DECISION DELEGATED TO HEAD OF PLANNING

Application No: H06-0732-25 **Applicant:** Mr S Mcauley

Proposal: Erection of Dwelling - re-submission of H06-1002-19 - approved under H06-0470-20. Amendment for the omission of one velux roof window to the roof of bedroom one.

Location: Olive Tree Lodge Marsh Road Gedney Drove End

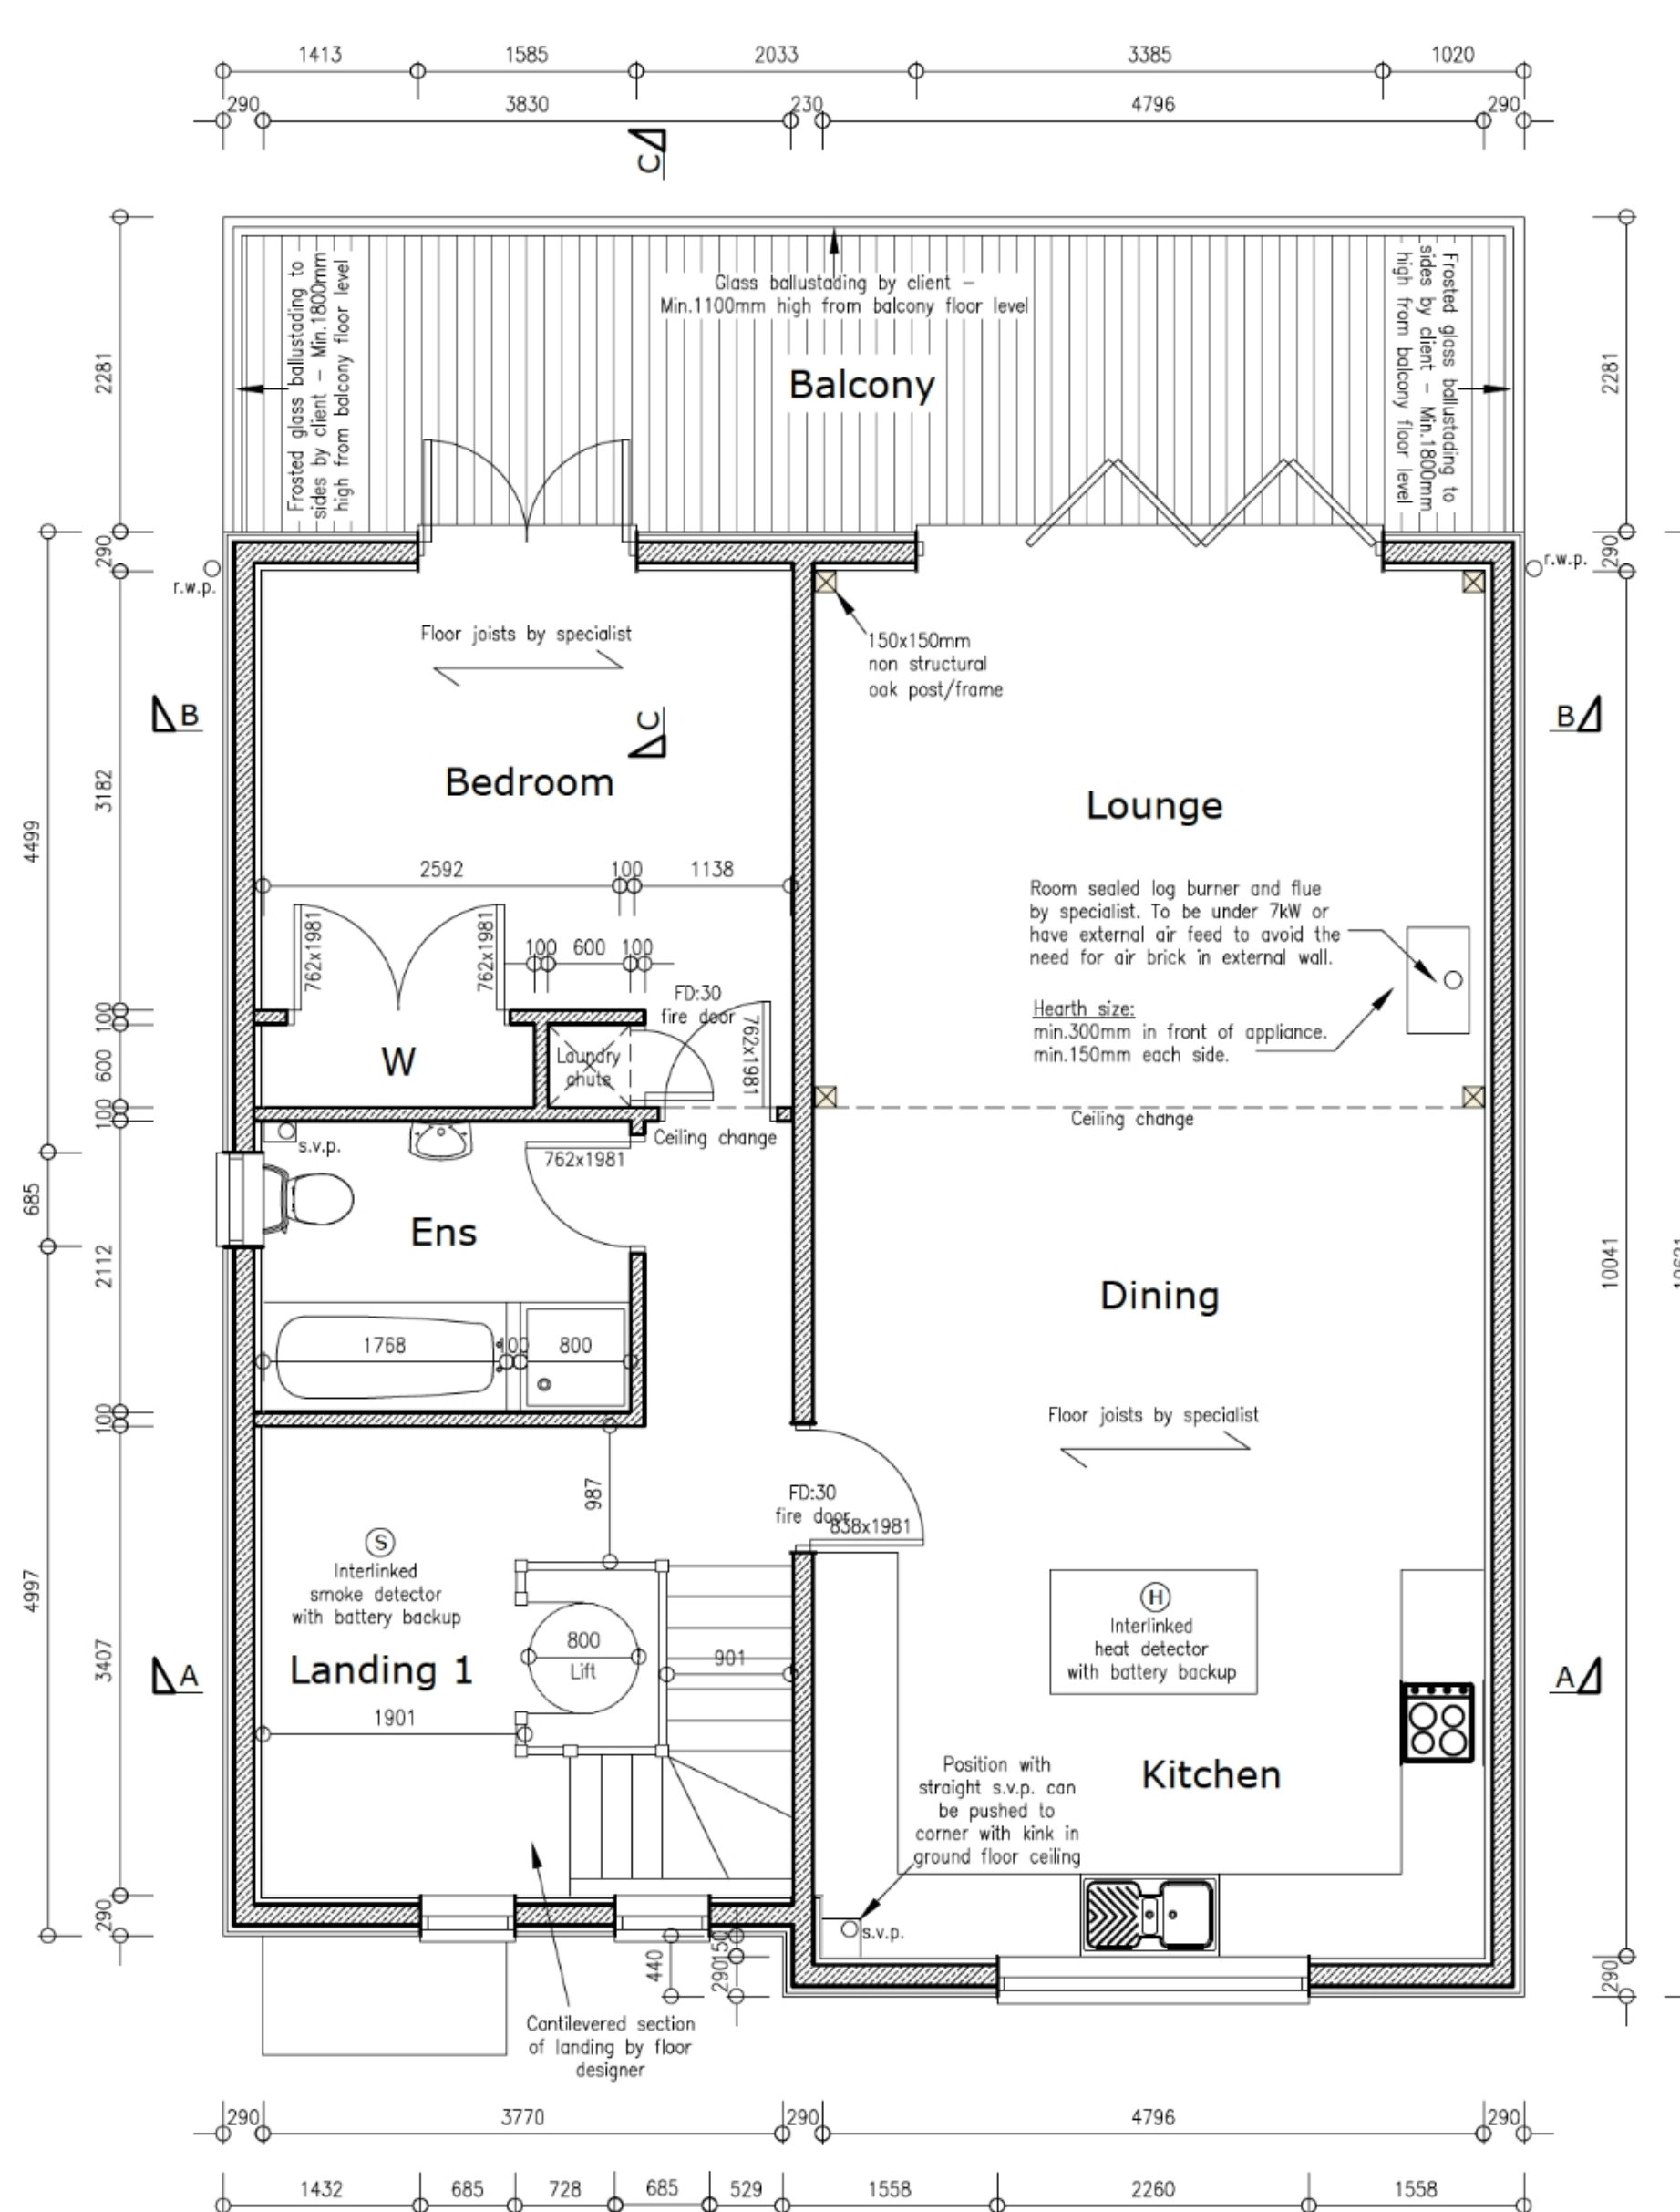
Consent is sought to amend the approved plans by proposing one rooflight on the southern roof slope, rather than two roof lights. The approved plans are listed under condition 2 of permission H06-0470-20. No other external changes are proposed.

The visual and amenity impact of the proposed change is acceptable. The proposed change to one rooflight instead of two rooflights is considered to be a non-material change that would not significantly affect the appearance of the dwelling. Furthermore, the loss of one of the rooflights would have an acceptable impact on living conditions within the dwelling as there would still be sufficient light within the bedroom that the rooflight would have connected to. Lastly, the proposed change would not undermine any of the other conditions that were previously imposed.
